BOTLEY WEST SOLAR FARM 11/09/25

COMMENTS ON THE APPLICANT'S RESPONSES TO QUESTIONS FROM ExA \_.

Project: AG1803	Sheet: Field 1.12
Date: November 2024	
Scale: 1 : 4000 @A3

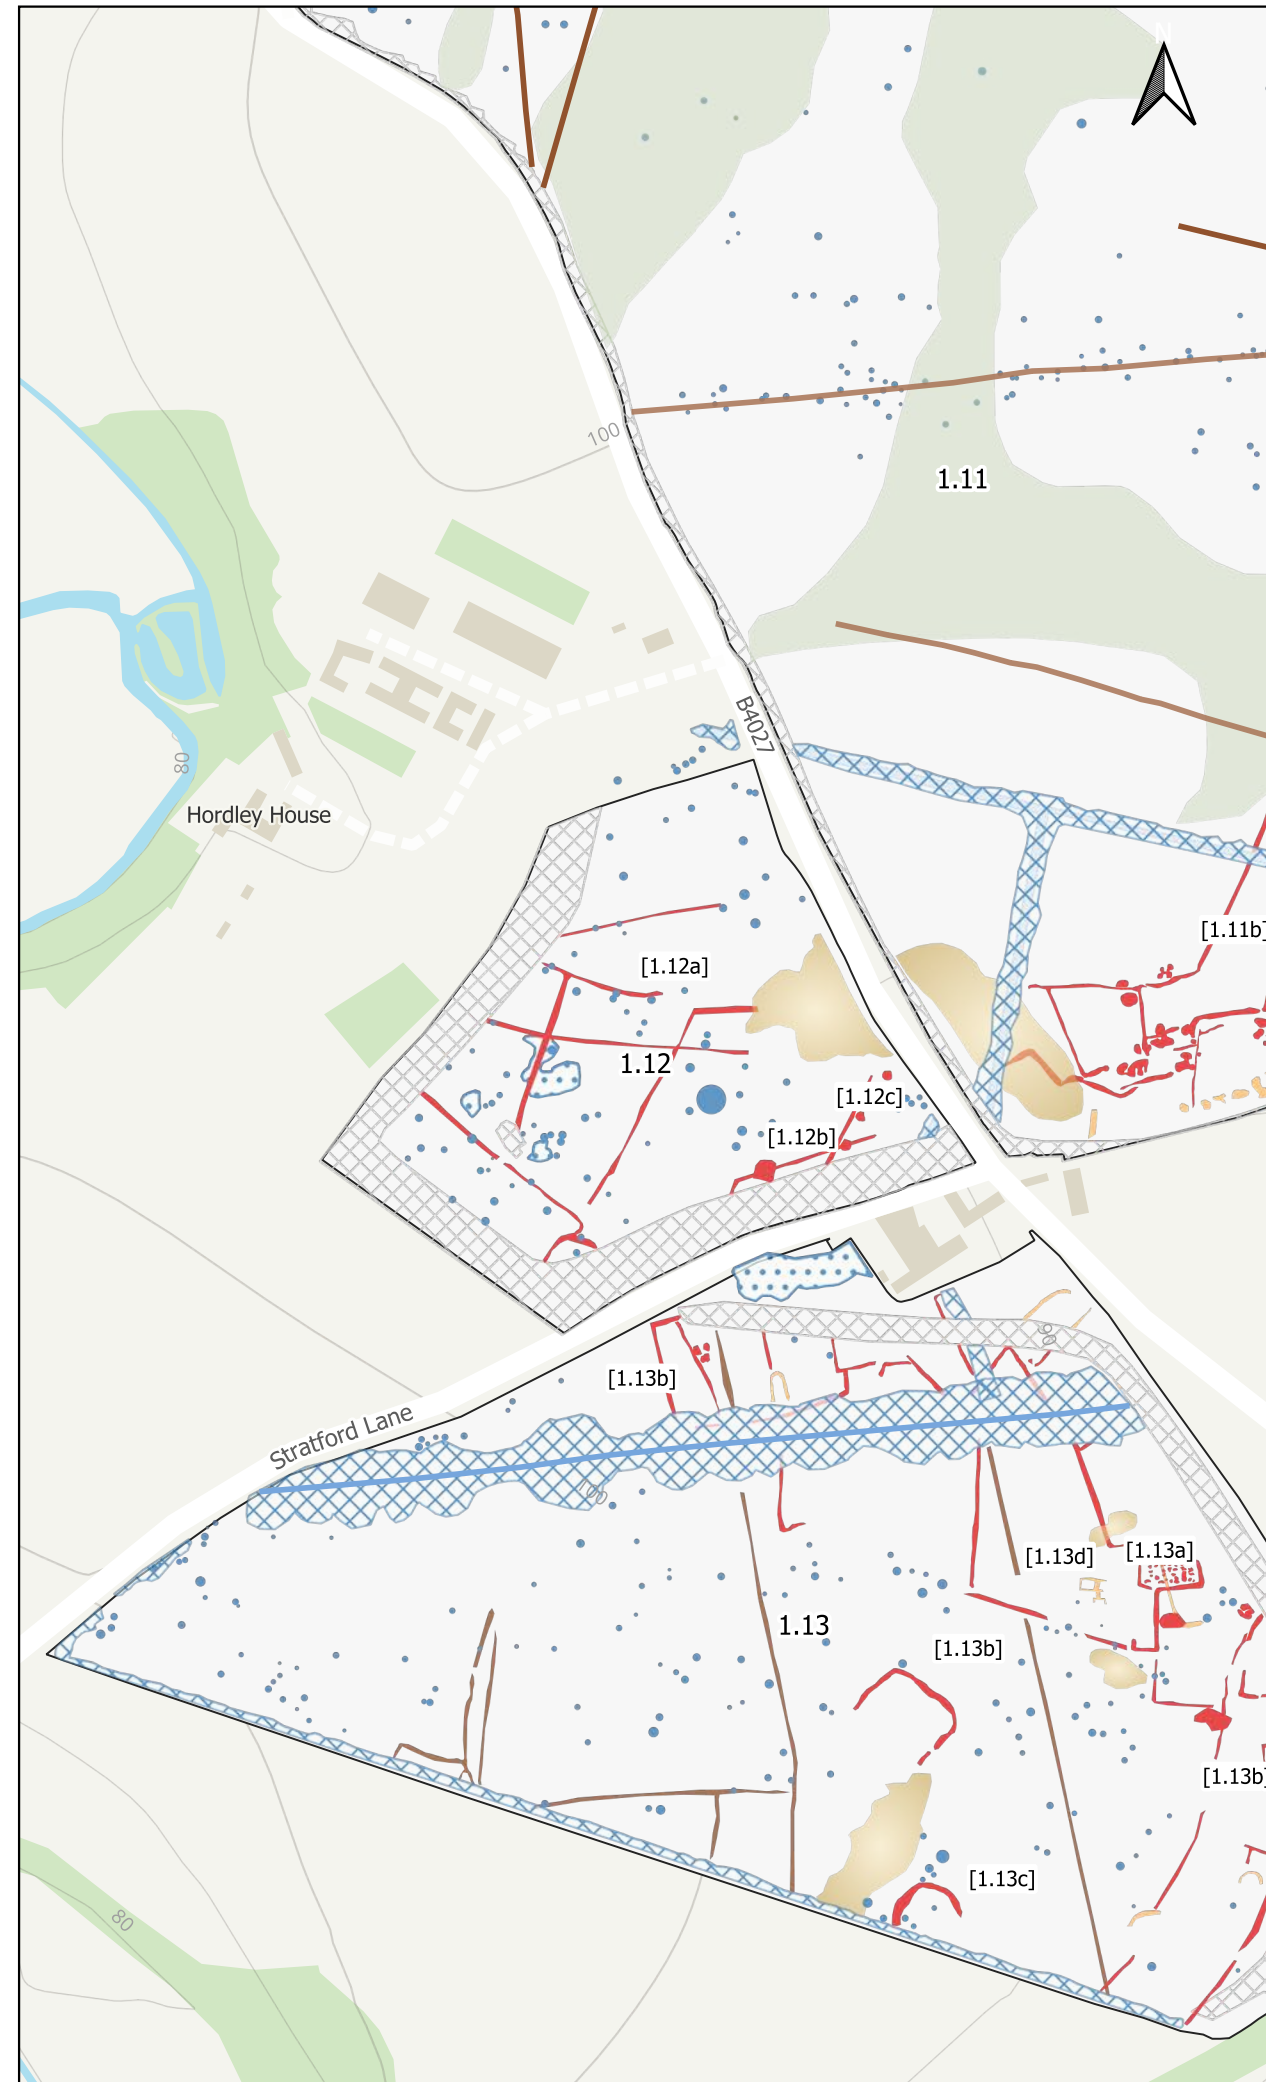
Q 2.3.2. Schedule 9 of The Electricity Act sets out clearly the obligations required for new installations which include "protecting sites of historic interest". Enclosure no. 1.12 already has nine single electricity poles and two doubles in two different power lines. Any further installations will clearly breach this duty.

Q 2.6.3. The setting of the WHS within the OUV is considerably spoiled by the inclusion of enclosures 1.11, 1.12 and 1.13 which have the effect of leading up to the WHS in an attractive corridor. All these should be taken out of the scheme. Field 1.12 in particular not only has two power lines crossing it but also a busy public footpath and a Heritage Oak Tree in the southern part.

The whole of field 1.12 should be taken out.

Project: AG1803	Sheet: Field 1.13
Date: November 2024	
Scale: 1 : 5000 @A3

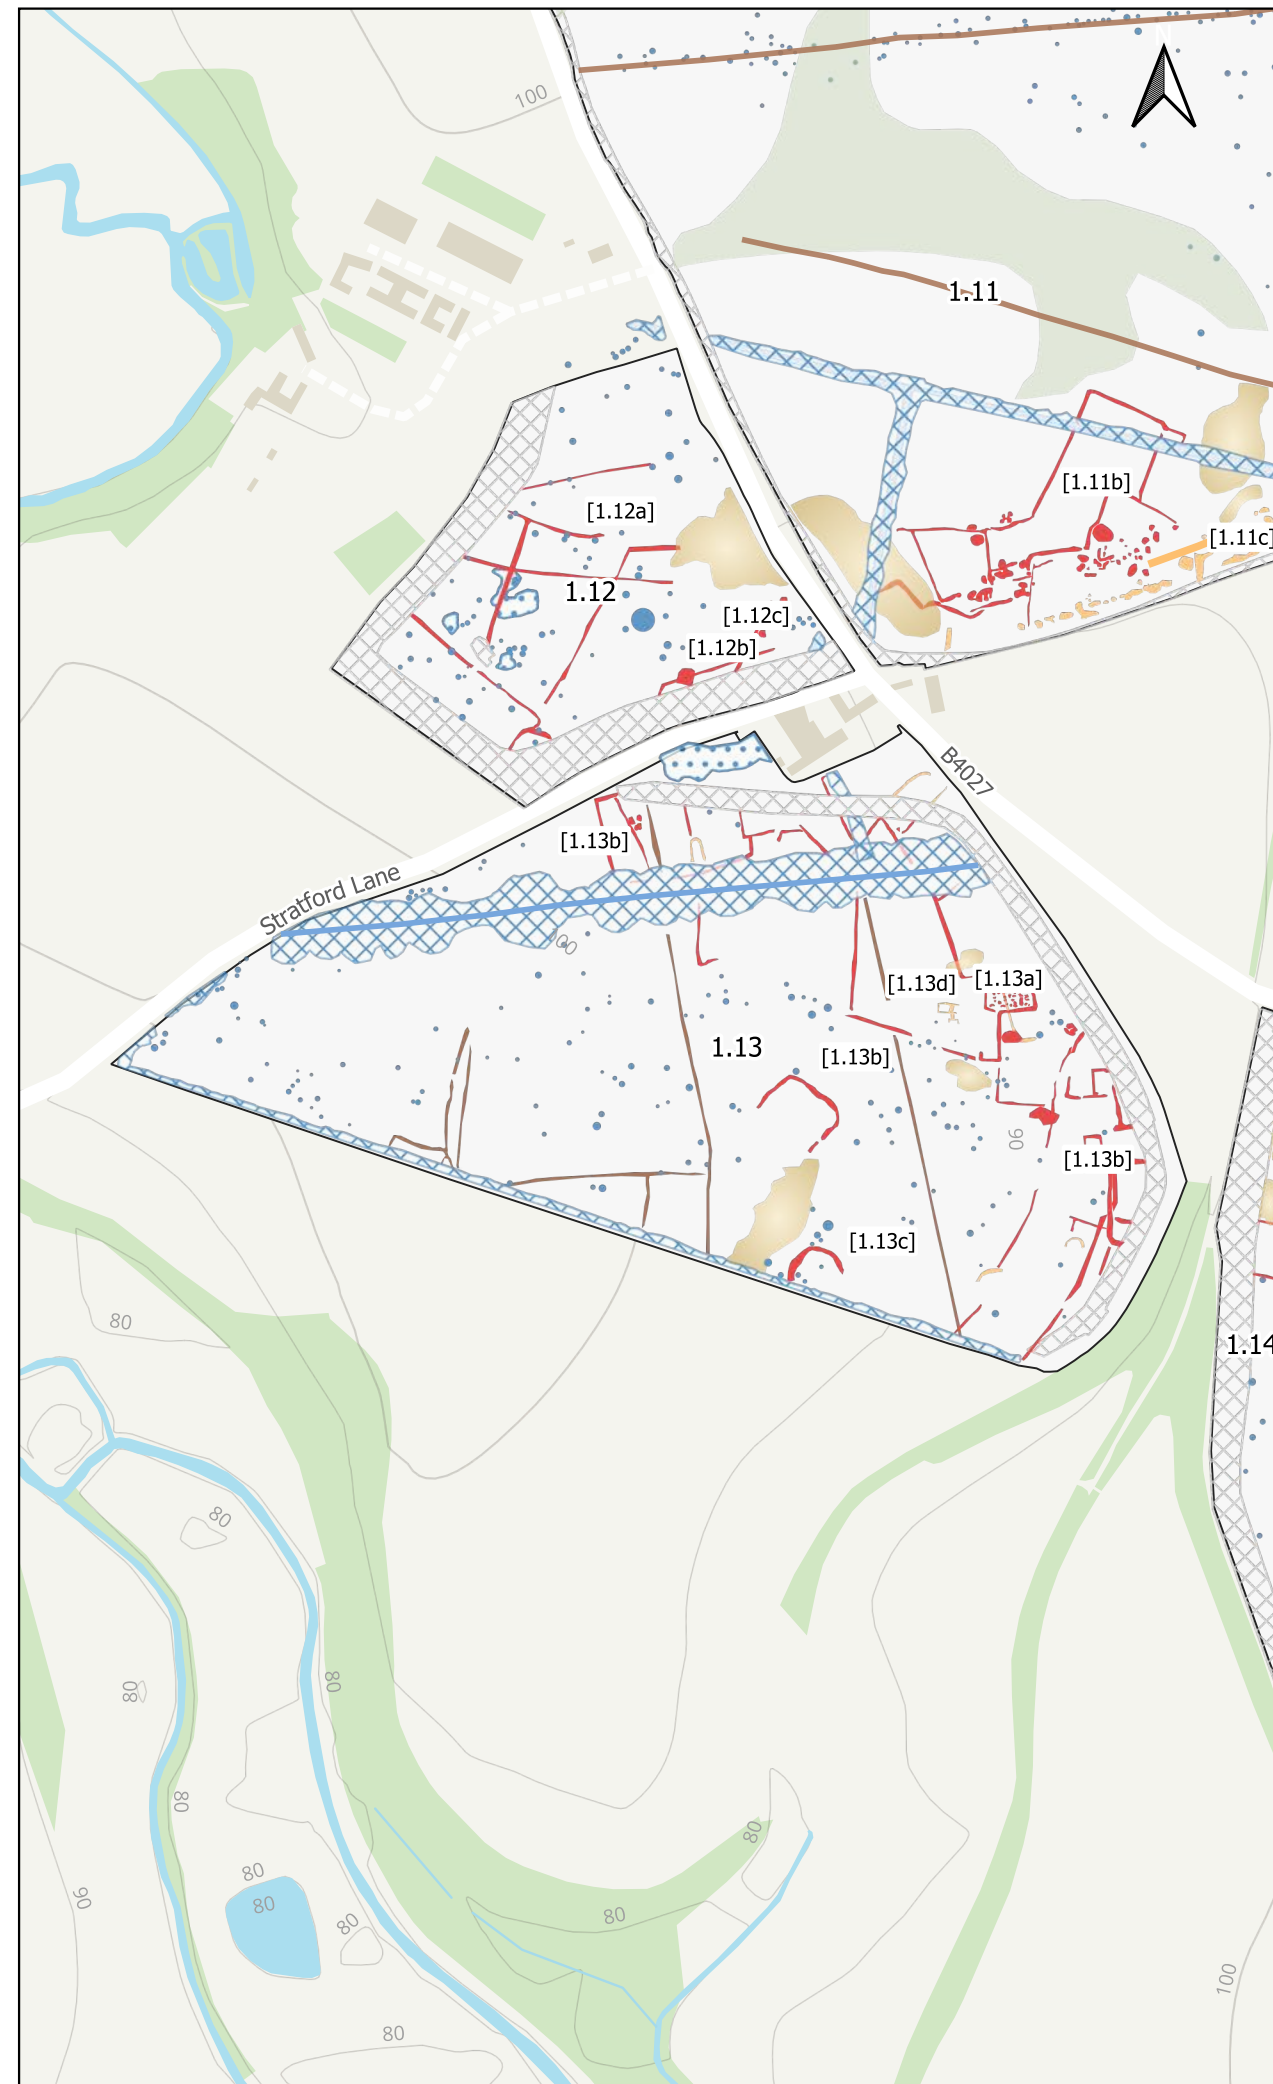
Field 1.13 can be seen in its entirety from the B 4027 and there is no roadside hedge to screen it. The hedge on its northern boundary will take many years to have any screening impact.
